Appendix J - Pre-DA Meeting Feedback Responses

Table 44 Newcastle City Council Pre-DA Meeting Feedback

# Ground Floor & Public Domain Plan

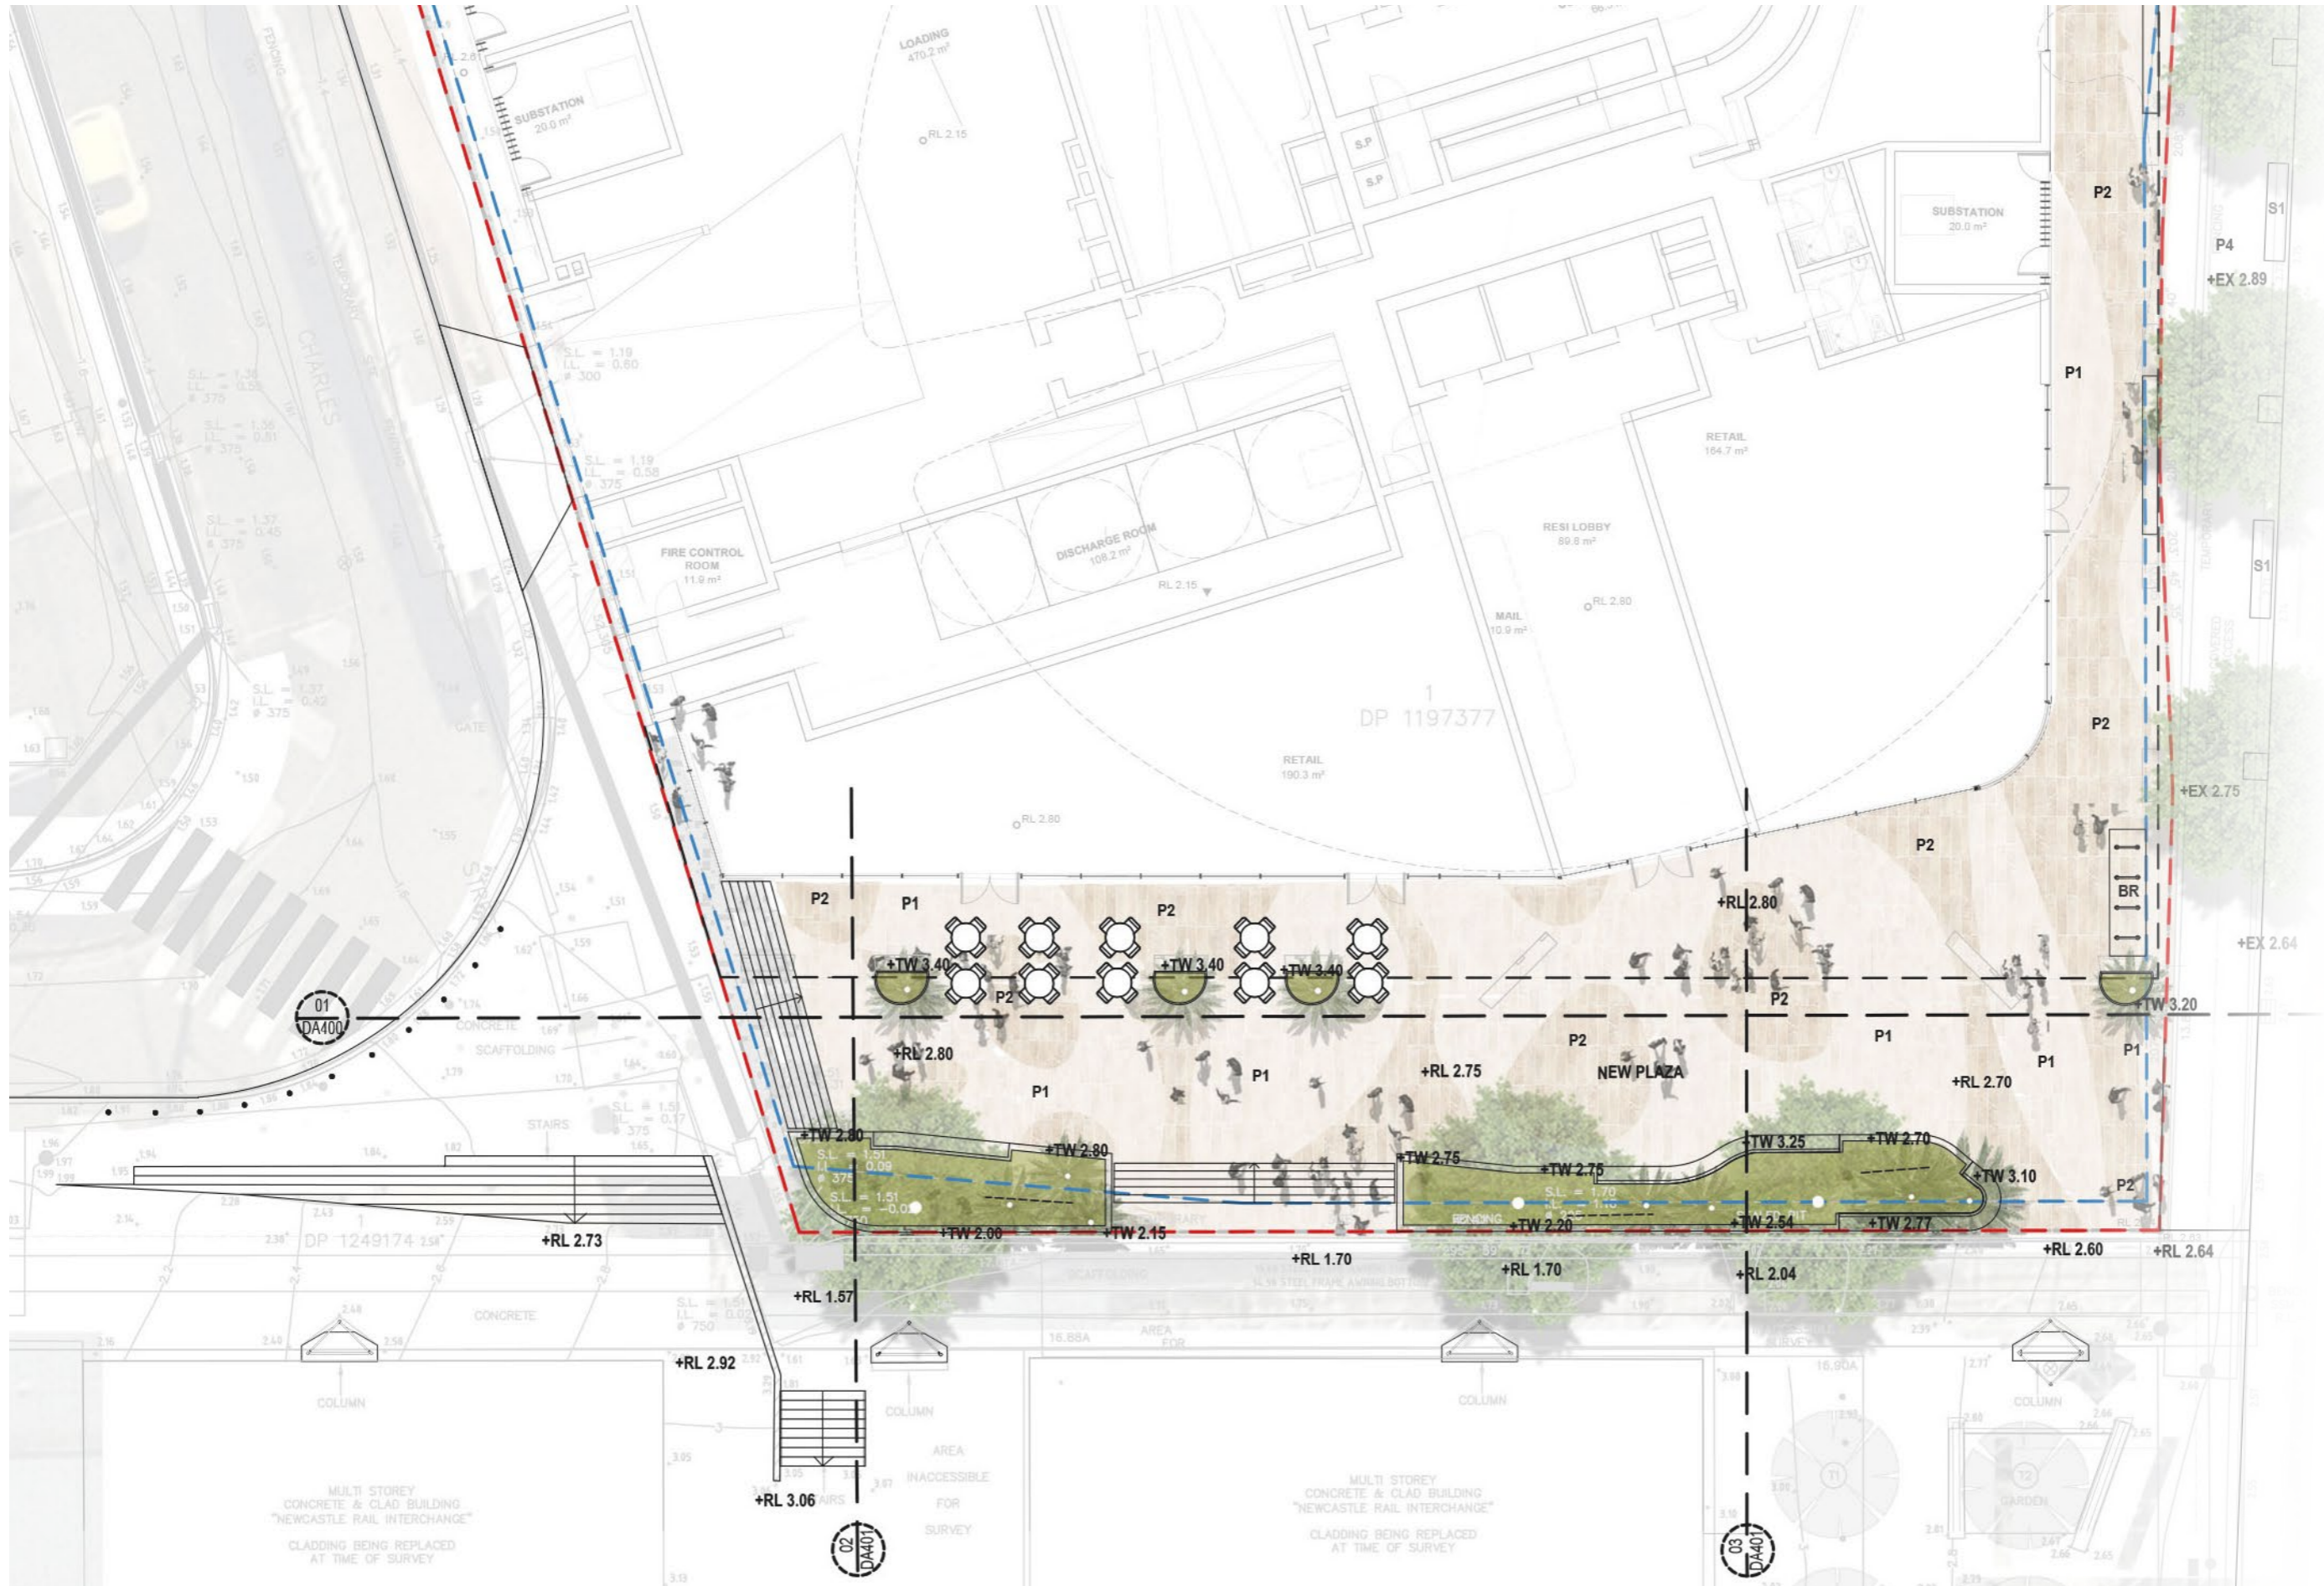
Landscaping – The ground floor landscaping adjacent the Newcastle Interchange will be in constant shadow from the proposed tower. Concern is raised that suitable landscape outcomes cannot be achieved in this instance as shown in the submitted landscape details. The landscaping is to ensure year-round usability of the site and communal open spaces should be of high quality, with adequate landscaping being essential. In line with Part 3D Communal and public Open Space of the ADG, well-considered landscaping design is crucial for supporting a variety of activities for both individuals and groups, while also responding to site-specific conditions by providing shade and shelter.	Refer to the Landscape Plans and Landscape Design Report, included at Appendix Z and Appendix AA respectively. Appropriate planting is provided for the climate.
Balconies/Private Open Space & Wind Loading – Concern is raised, resulting from the round design of the floorplates, regarding the shape and functional use of the balcony spaces. This may need to be rationalised to ensure effective usable spaces for future residents. The overall design of the balconies, inclusive of any structures such as fins/blades, will need to be considered in combination with wind loading impacts which will be substantial in this location and at the heights proposed.	Refer to the Assessment against the ADG included within the Architectural Design Report at Appendix M . Adequate balcony areas are provided for the proposed dwellings. The Pedestrian Wind Study (Appendix P) concludes, subject to the implementation of the proposed mitigation measures, the balconies will be usable spaces for future residents.

# Level 6 Residential Communal Open Space

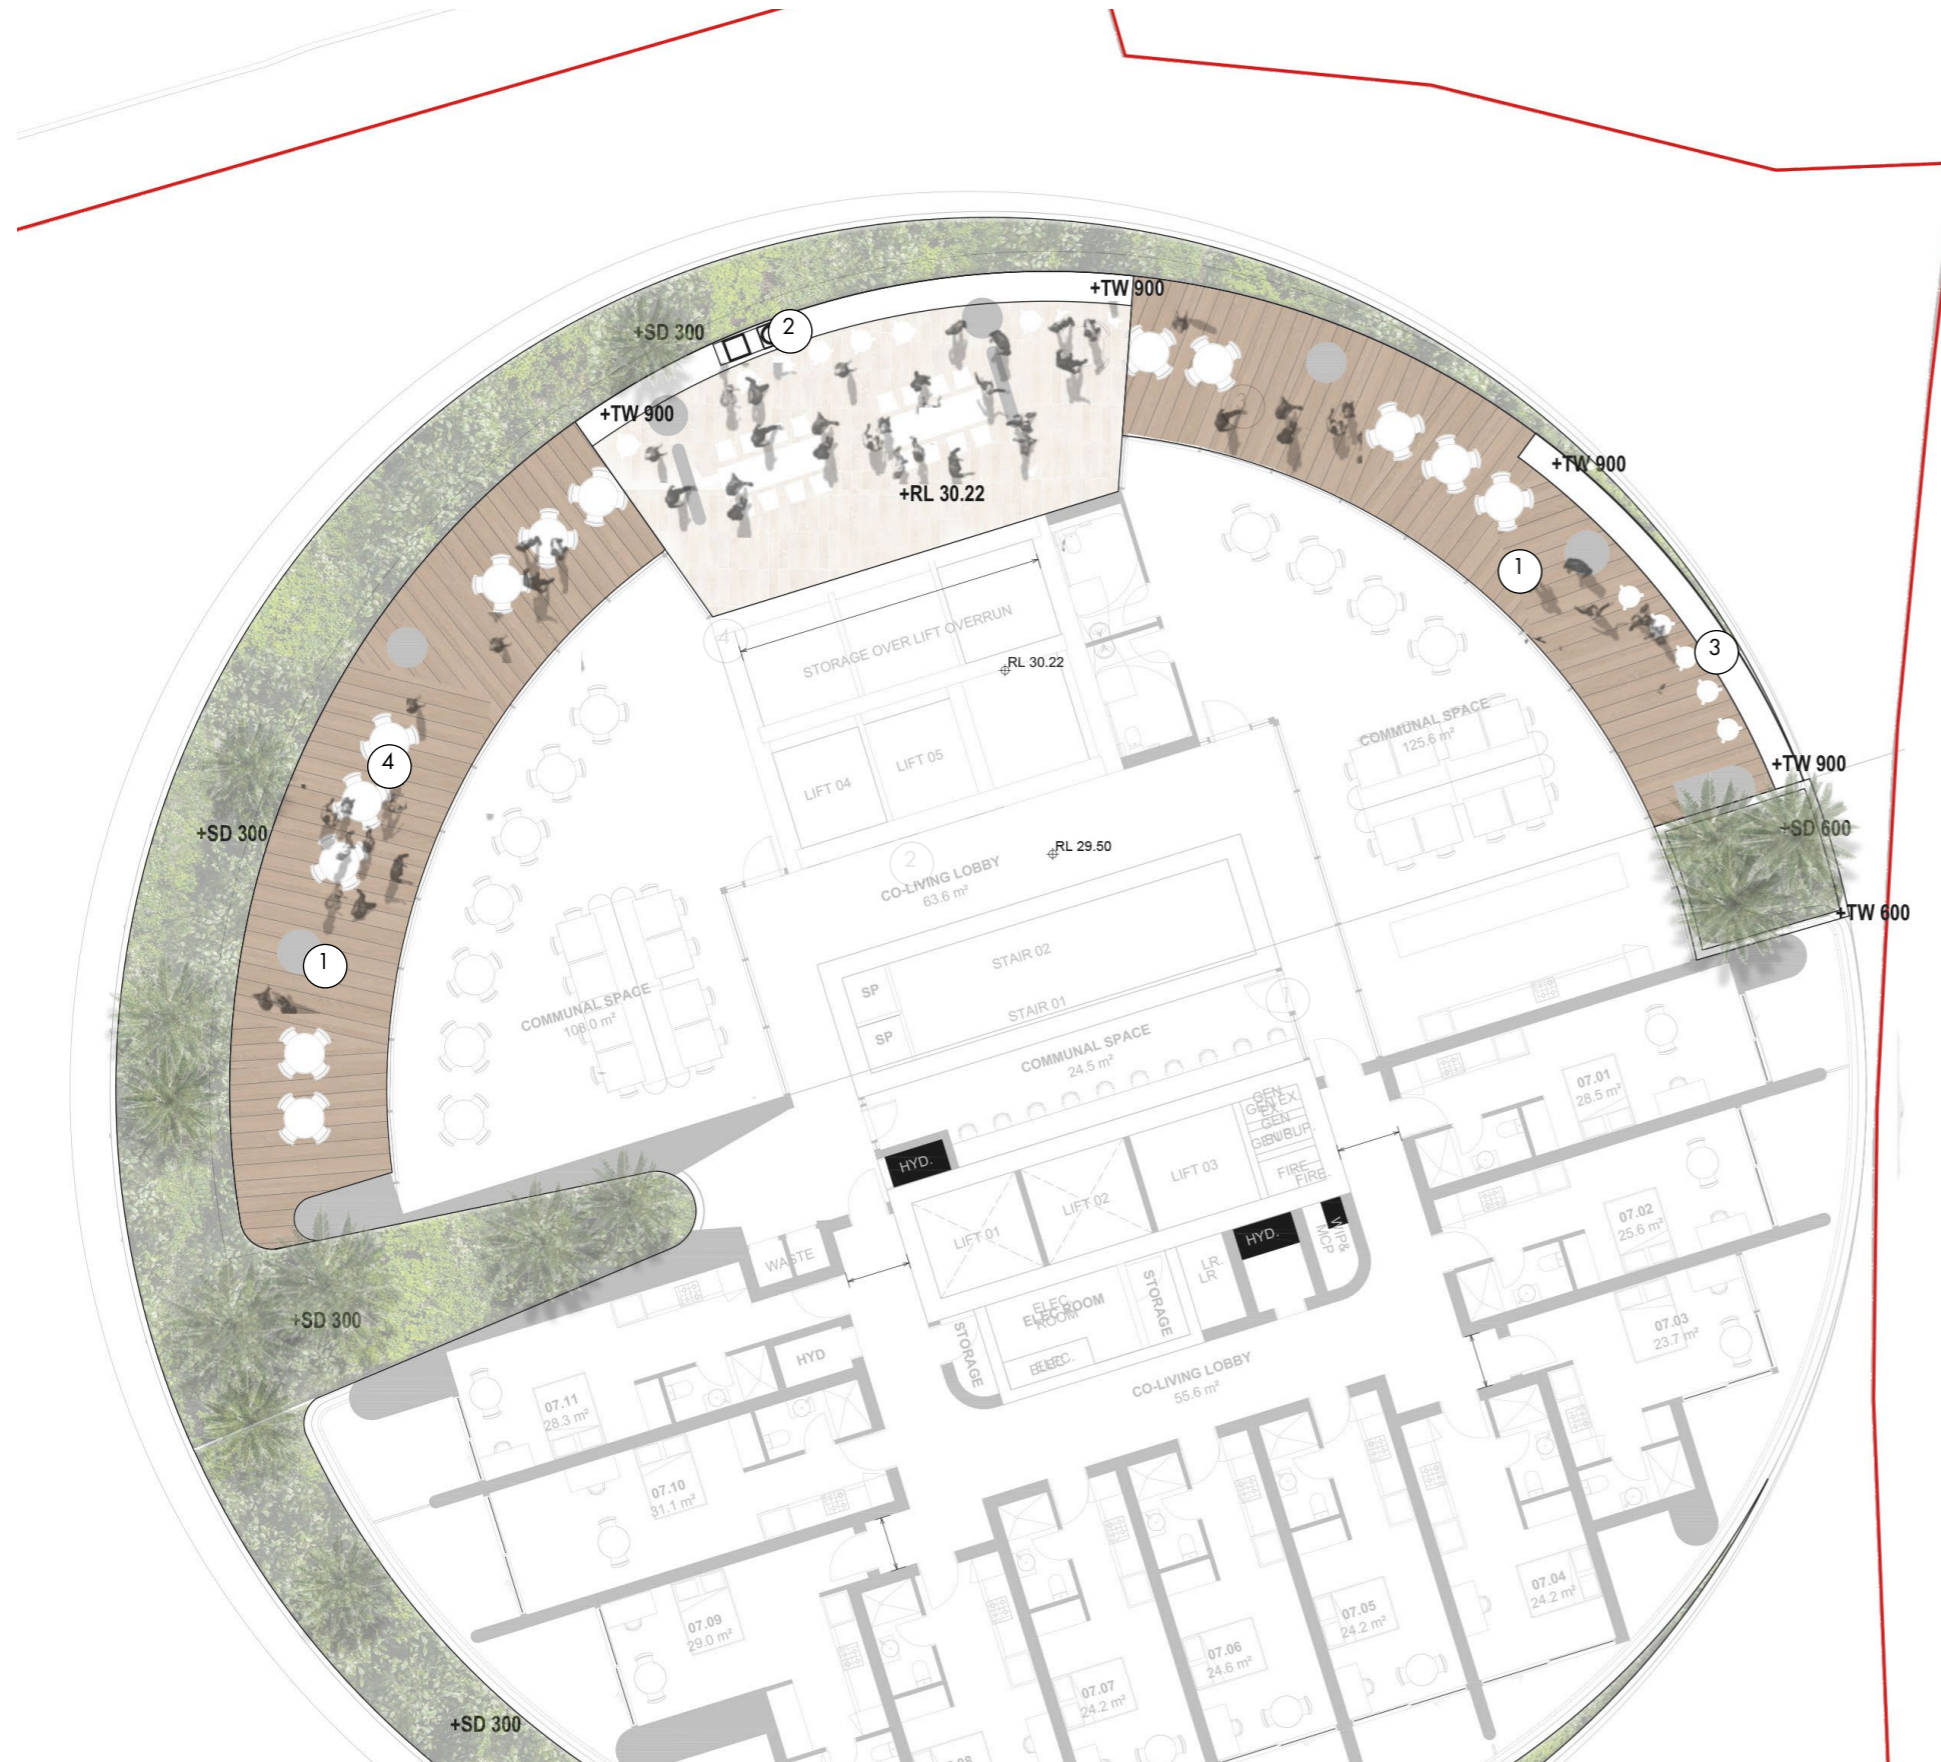
Communal Open Space – Concern is raised that sufficient open space is provided for the residential apartment residents. Additionally, how open space is provided and managed between the differing elements (i.e. hotel, co-living and residential apartments) needs to be addressed. It would not be appropriate that these communal open space areas be combined or overlapped, especially by hotel guests in what would otherwise be private resident spaces.	Sufficient communal open space is provided for each of the residential components (market, affordable and co-living). Refer to Section 5.9.4 and Section 8.2.3 of the EIS for further discussion on communal areas and their allocation.
Deep Soil Areas – The proposal has not sufficiently demonstrated that the proposed achieves the 7% deep soil areas.	Refer to Section 8.2.3 for discussion on deep soil and compliance with the ADG.
Universal Housing – It is confirmed under NDCP that 20% of the residential apartments and 100% of the co-living is to achieve platinum level liveable housing.	The proposal includes 57 units as Silver Level Liveable Housing Units and 28 units as Platinum Level Liveable Housing, meeting the requirements of the BCA. It is emphasised that pursuant to Section 2.10(1)(a) of the Planning Systems SEPP, DCPs do not apply to SSD.
